MEMORANDUM

TO: All Staff
FROM: Public Works Planning Review Team
DATE: November 23, 2020
SUBJECT: Slater CB-20-00009
Tax Parcels: 463337, 473337, 493337, etc.

WHISKEYDICK RIDGE

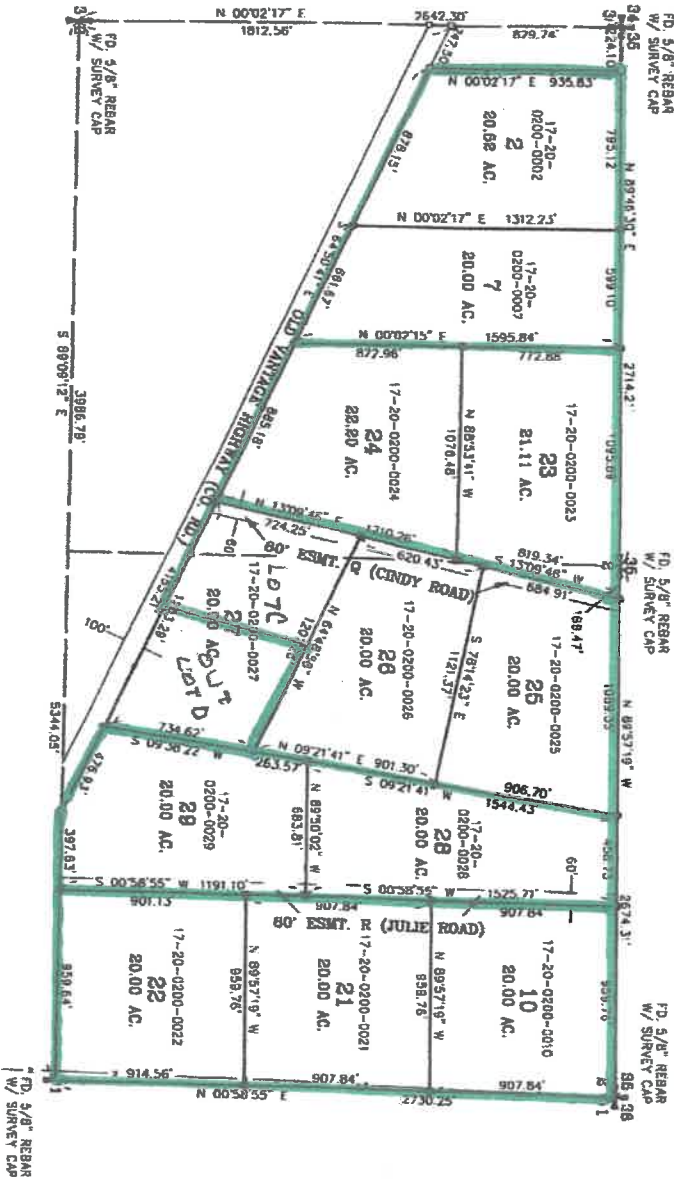
- a) Slater Road will be a shared access for 2 lots.
- b) Cindy Road & Julie Road would need to meet current private road standards for 3-14 lots. See Private Road Minimum Design Standards table 4-4A.
- c) Any further subdivision or lots to be served by proposed access may result in further access requirements. See Kittitas County Road Standards.
